Application Reference: 2025/0555

Location: 10 Flax Lea, Worsbrough, Barnsley, S70 5PZ.

This application seeks planning permission for a loft conversion facilitated by front and rear dormer windows, and alterations to an existing rear extension.

Drawing Title **PROPOSED ELEVATIONS**

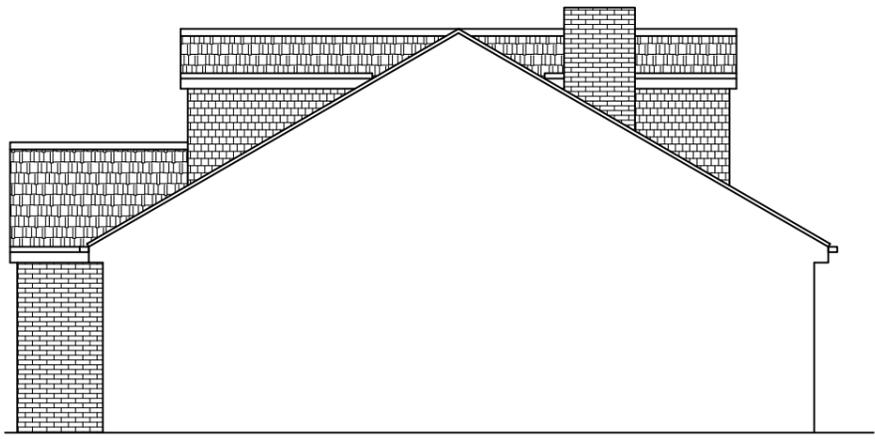
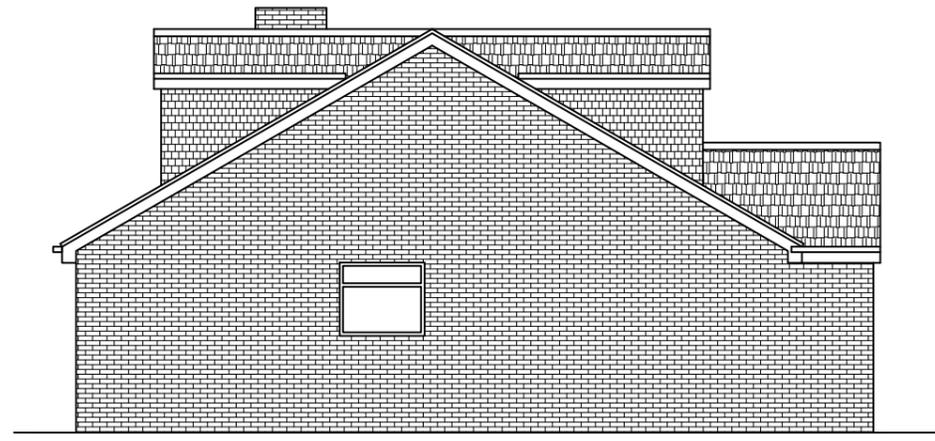
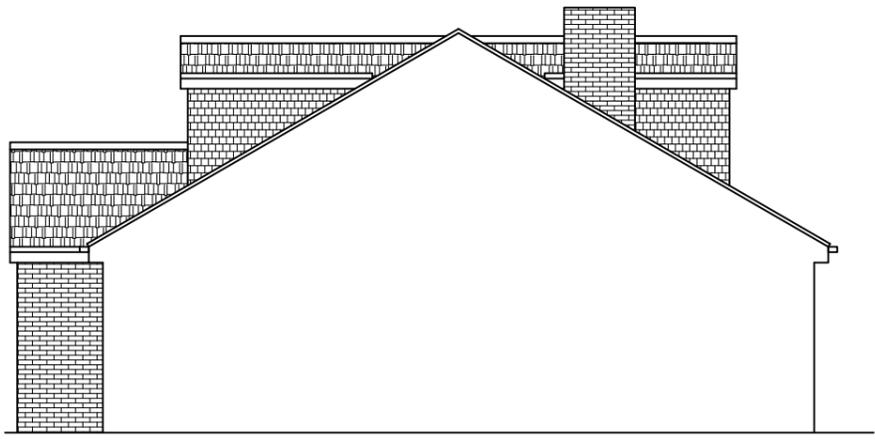
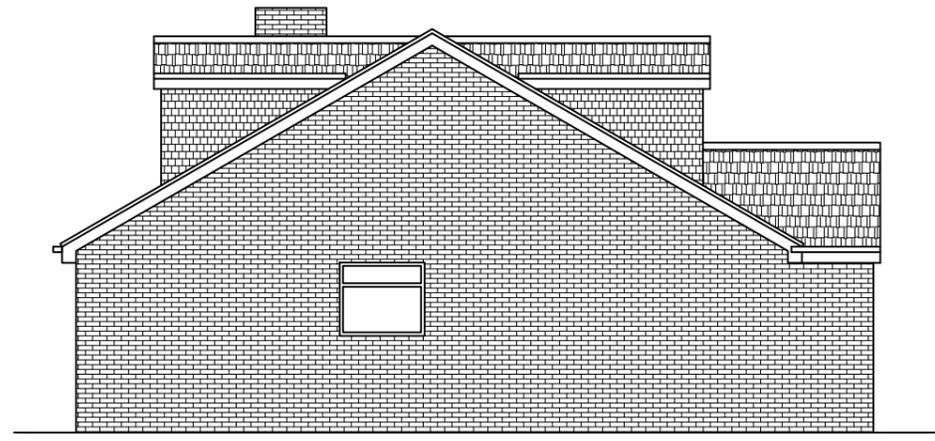
During the application process, the proposal was amended to set the dormer windows below the existing ridge.

- *Set the dormer windows below the existing ridge.*

Proposed Elevations MDW001 003 Rev. A received 12th August 2025.
